**Addendum No. 1**

RE: Contract ID C202787

Bridge # 11 On US-117 Over the North Cape Fear River and Bridge # 13  
On US-17/74/76/421 Over the Cape Fear River

**June 21, 2011 Letting**

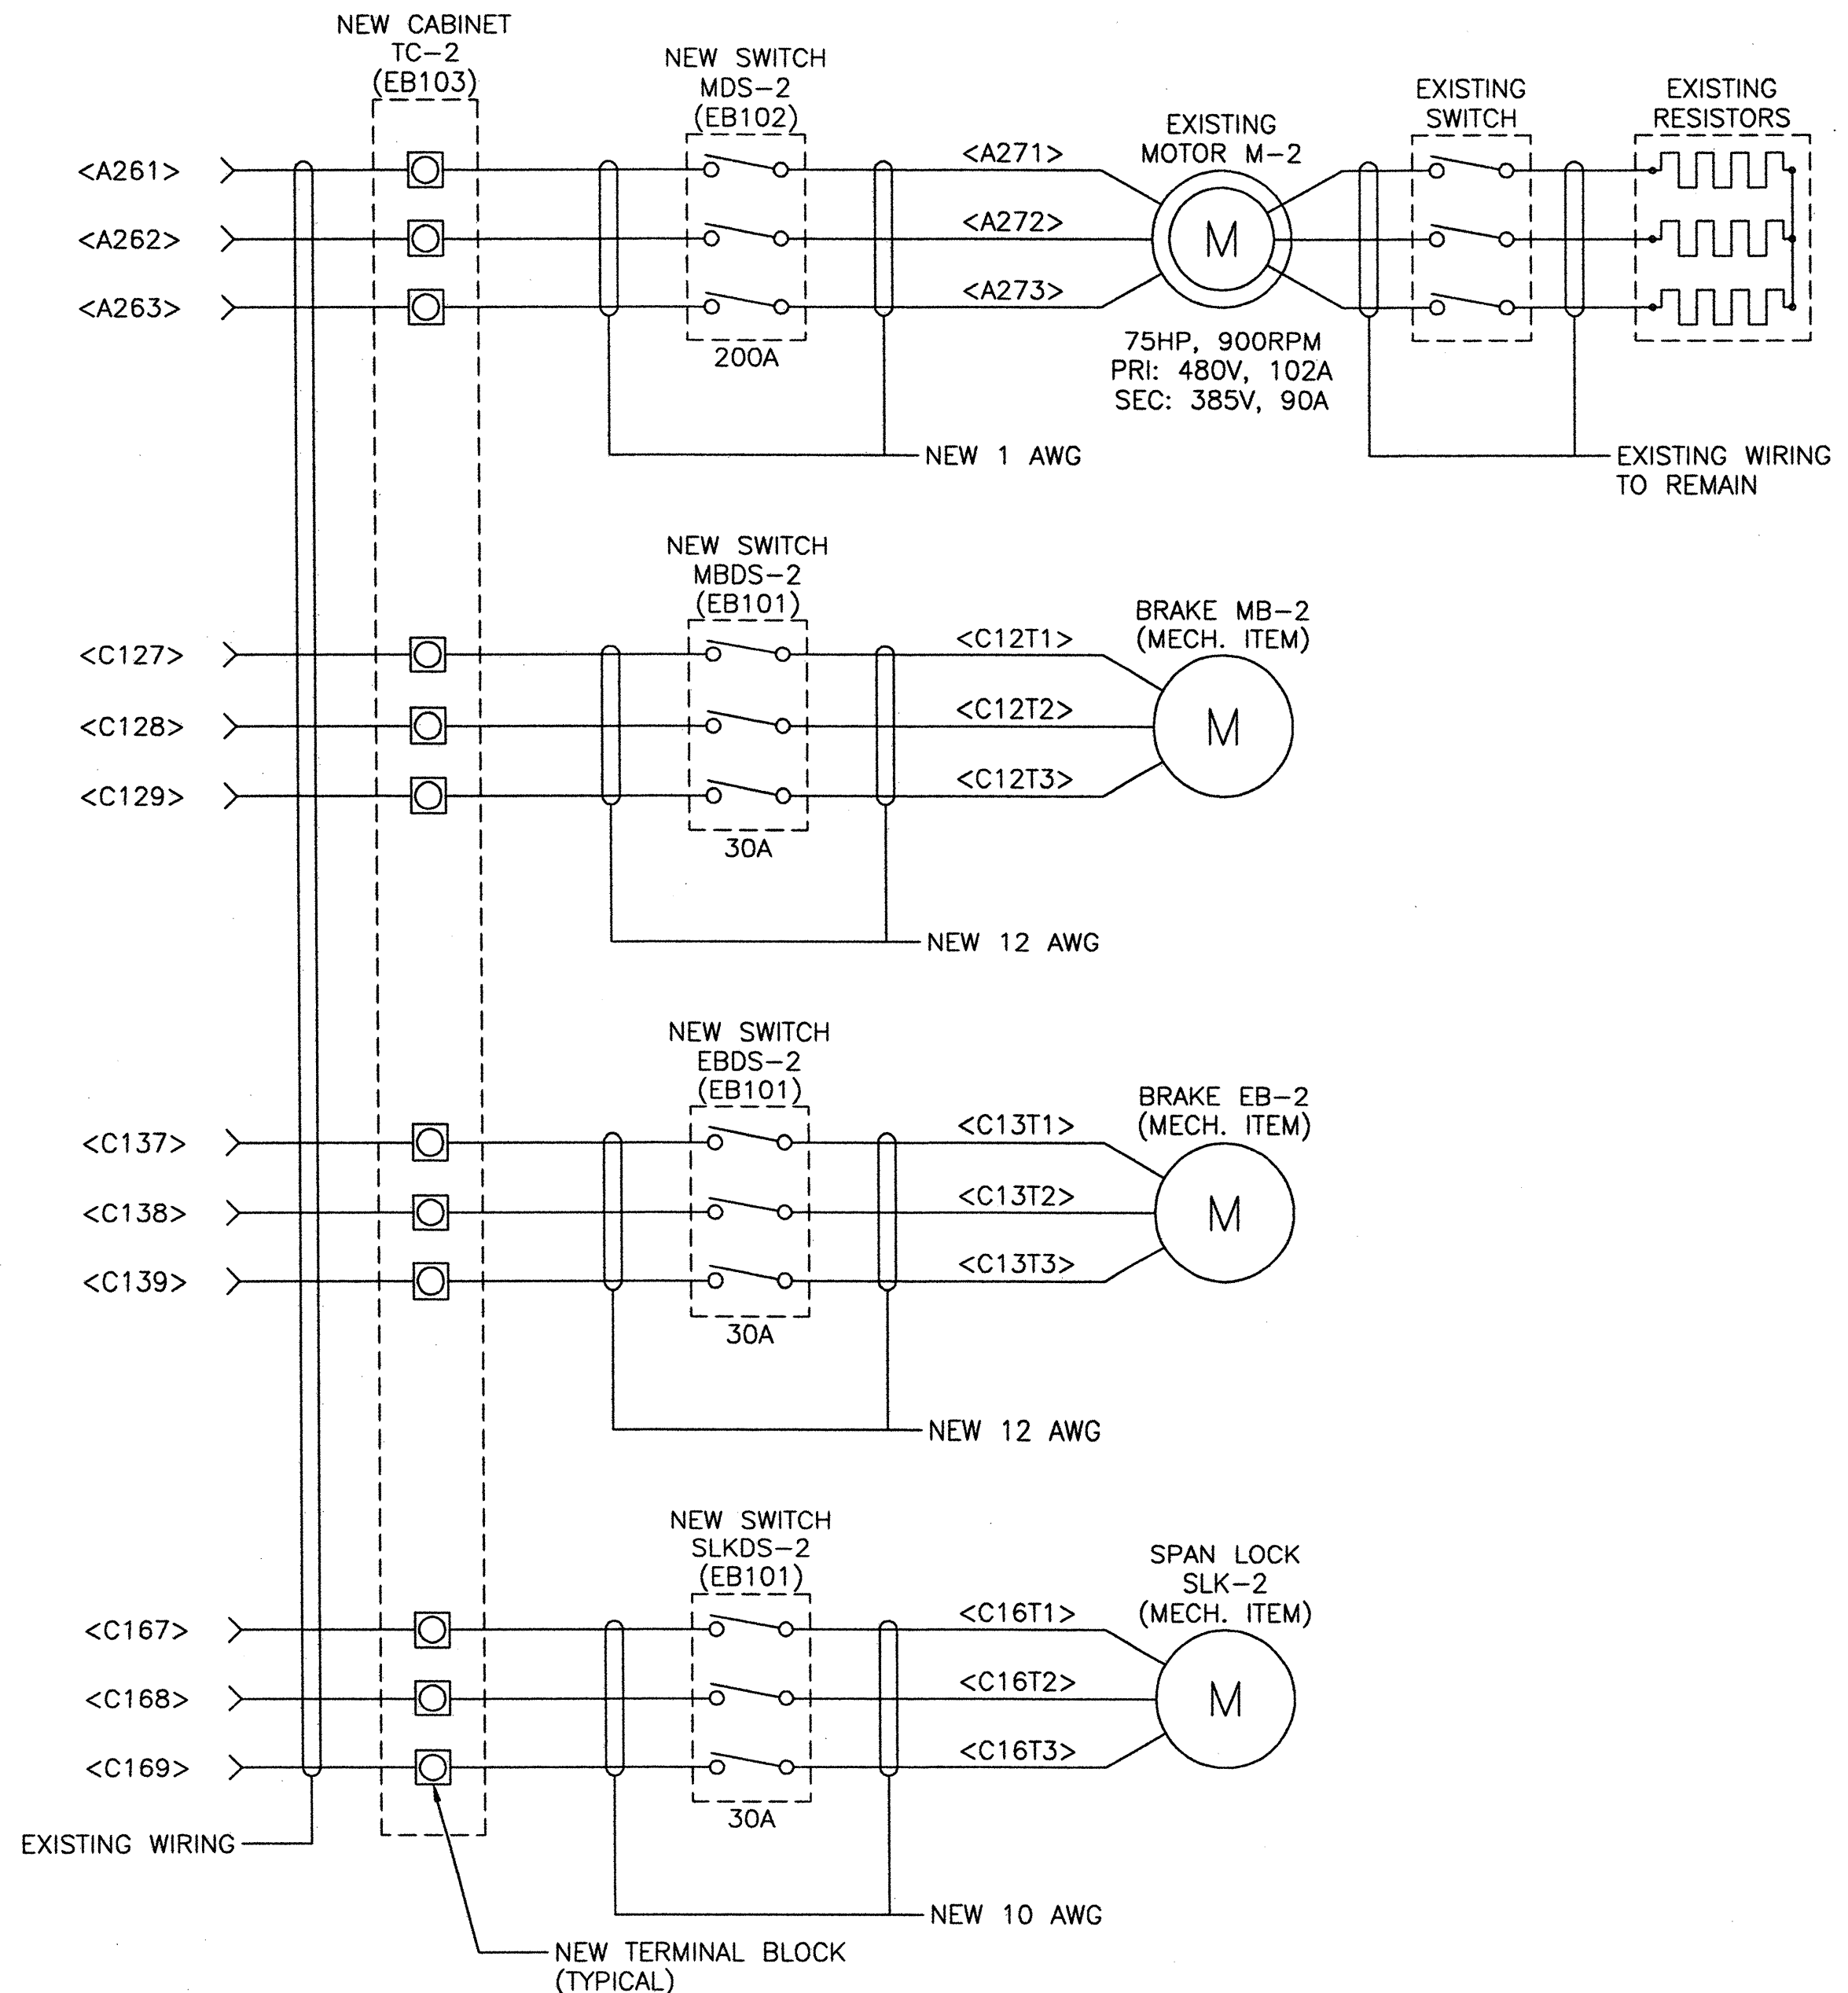
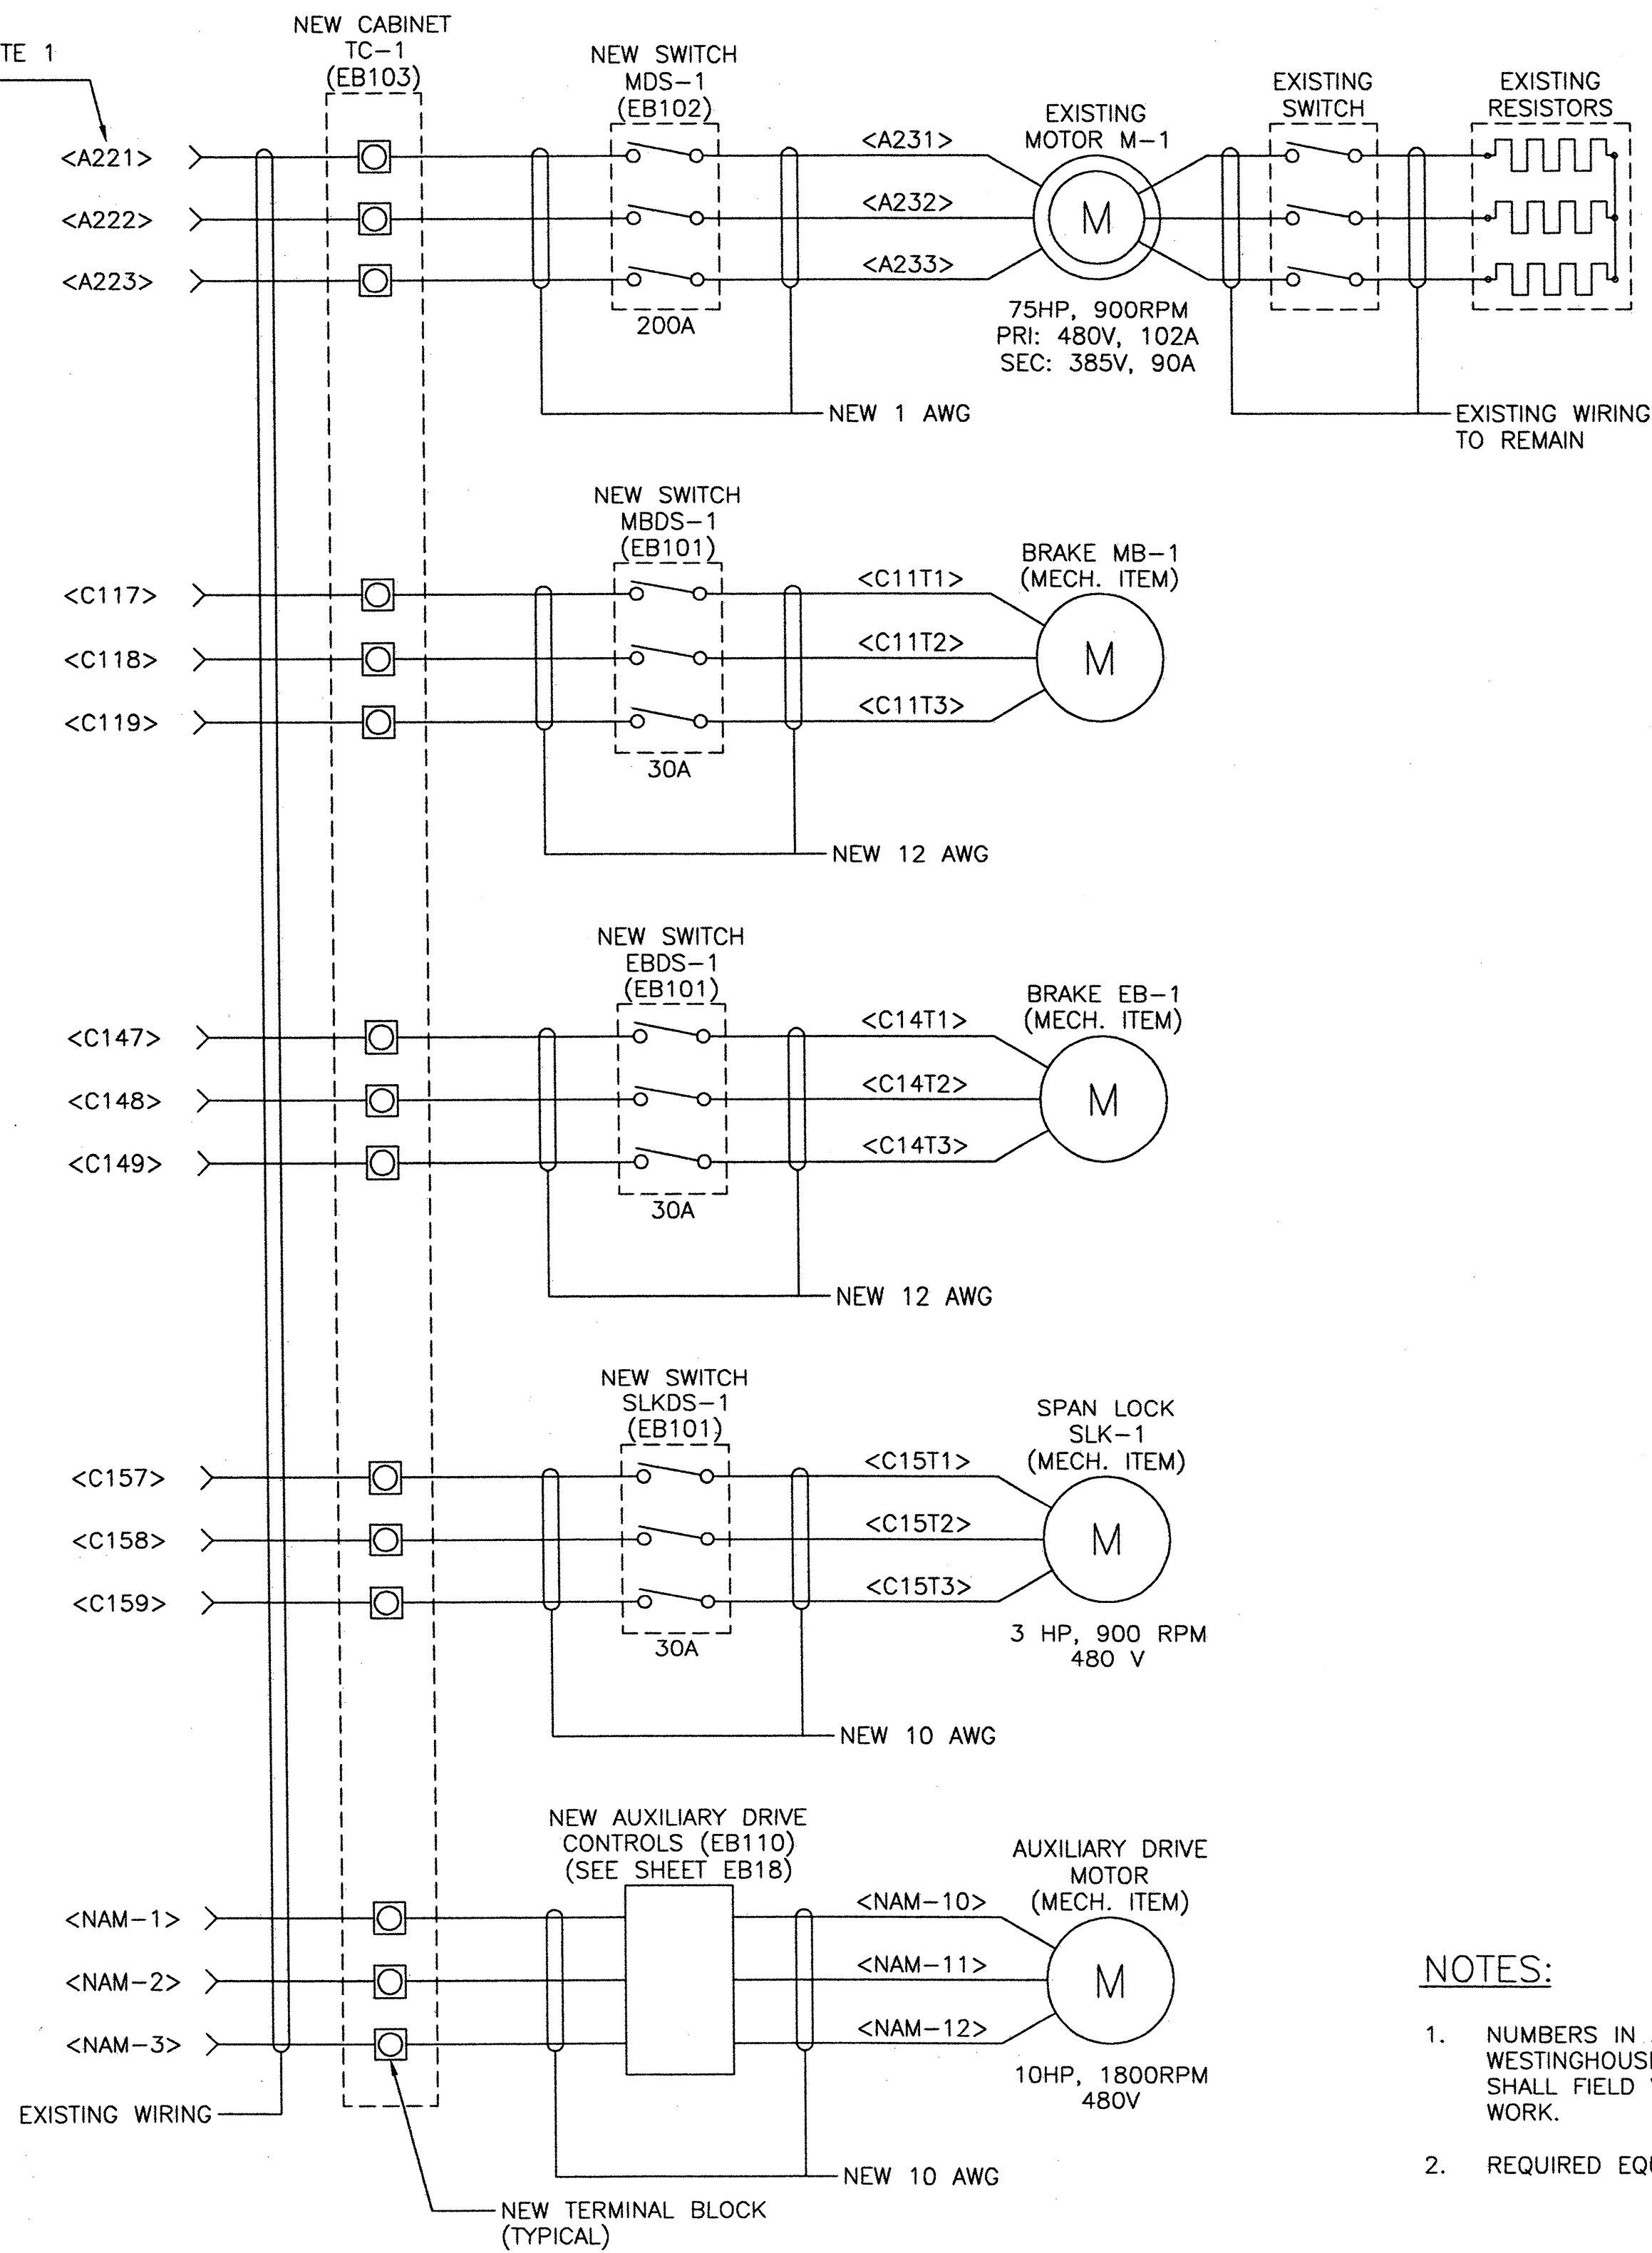
Drawing Nos. 39 (EB13) and 50 (EB24) have been revised to change the "Live Load Limit Switch (Item EB118)". Please void Drawing Nos. 39 and 50 in your plans and staple the revised Drawing Nos. 39 and 50 thereto.
